**Re: 330 Church Street, Parramatta - Modification to MP 10\_0171 Mixed Use  
Residential Development; Meriton Apartments**

**Re: MP 10\_0171 MOD – 330 Church Street, Parramatta  
Mixed use development - Former David Jones store and adjacent site**

**Major Project 10\_0171 MOD 3, 330 Church Street, Parramatta  
Mixed use residential and retail development**

01 - SHORT SECTION LOOKING WEST
1:200 @ 1

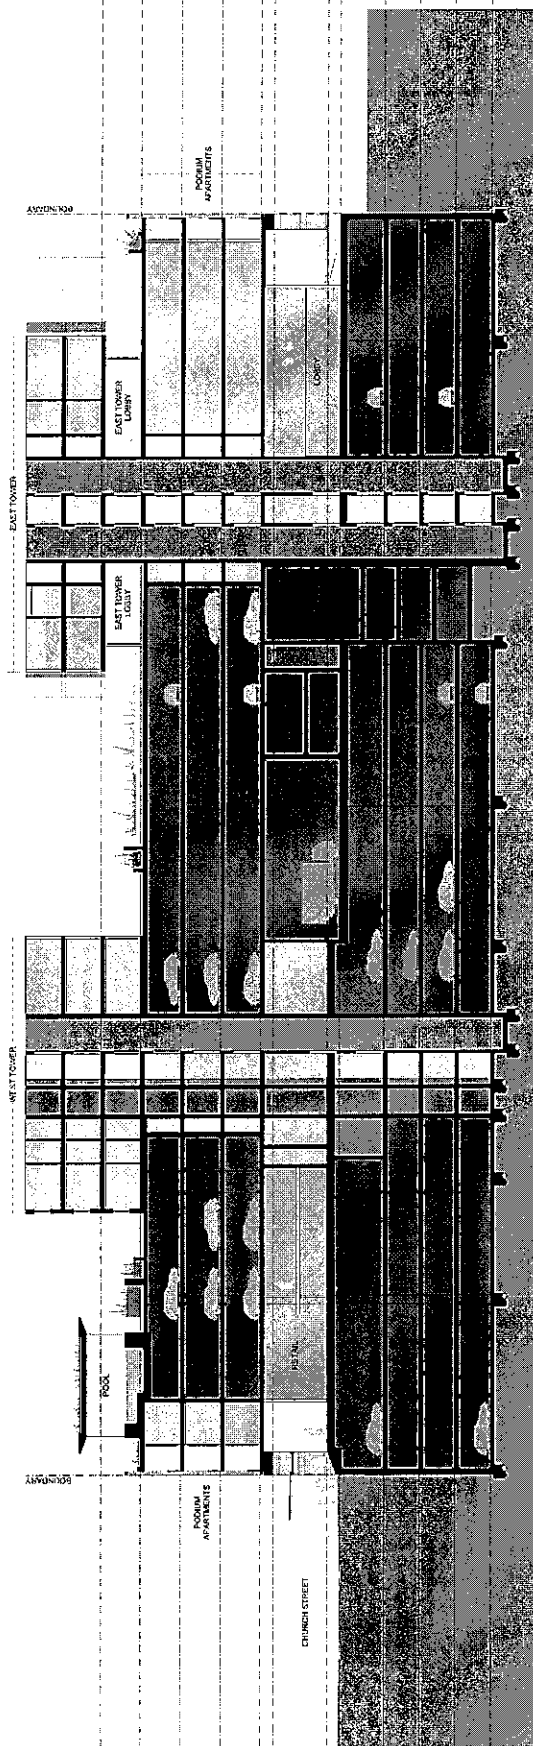
*The proposed development exceeds the height controls for the site, with the eastern (109.3m) and western (177.1m) towers both significantly above the 88m maximum height (with design excellence). The additional height alters the built form relationship between the towers. As a result, the height difference appears more pronounced and less complementary in the perspectives.*

01, ELEVATION - WEST
1:200 @ A1

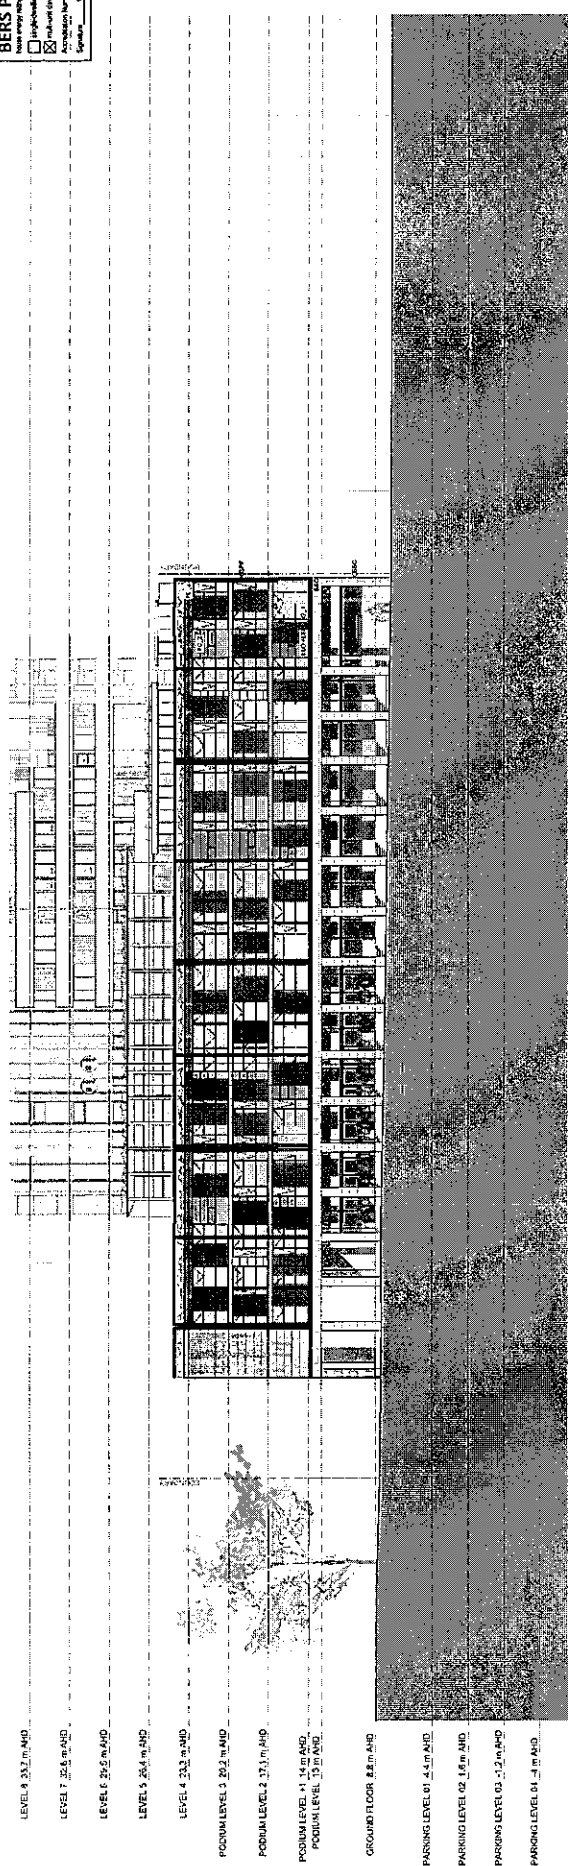
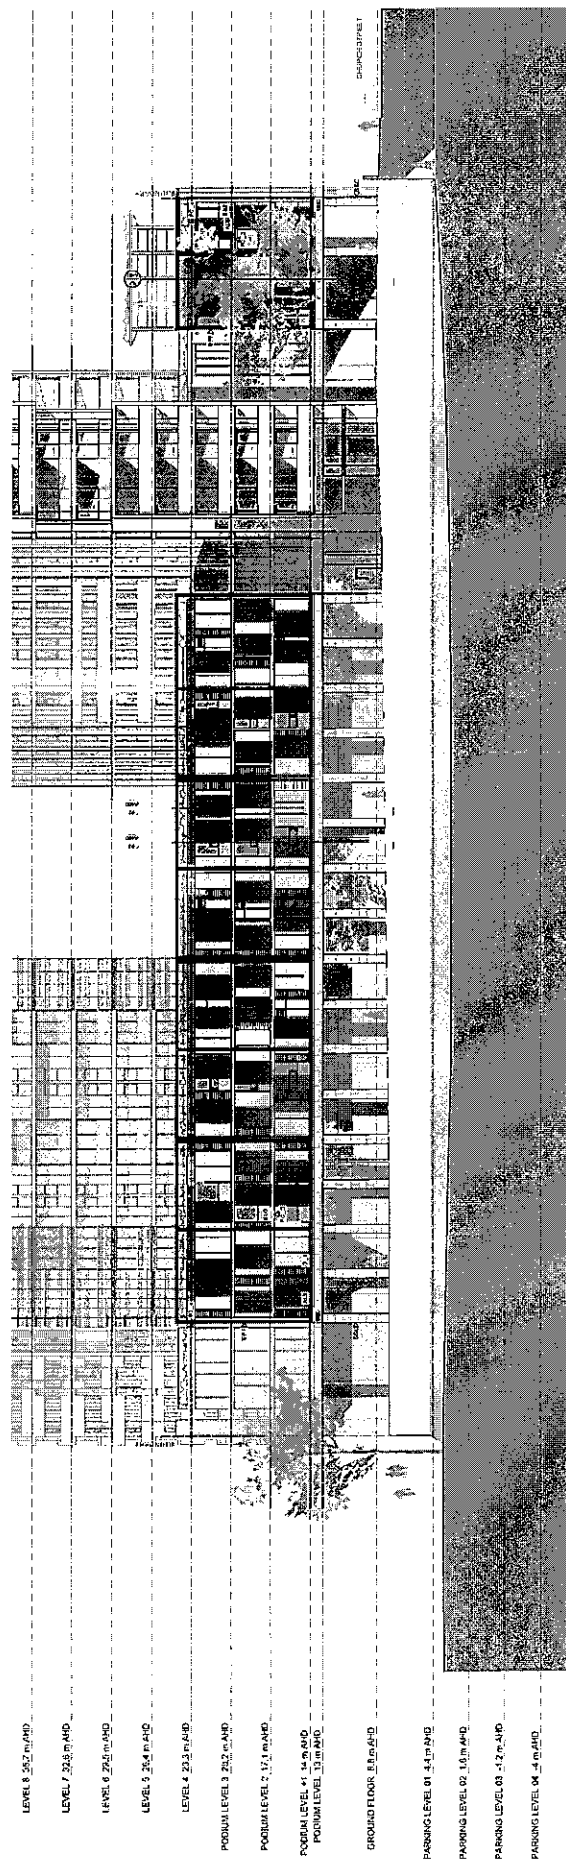
**Church Street – Street Frontage Height** *The proposed podium exceeds the DCP Street Frontage Height for Church Street but is shown to relate to the datum established by the dome at the corner of Phillip and Church Street.*

*The steps along the Church Street frontage are not supported and the proposed floor levels of the ground floor retail tenancies and colonnade should be lowered to meet the existing street levels, as per Section 3.2.C of the City Centre DCP.*
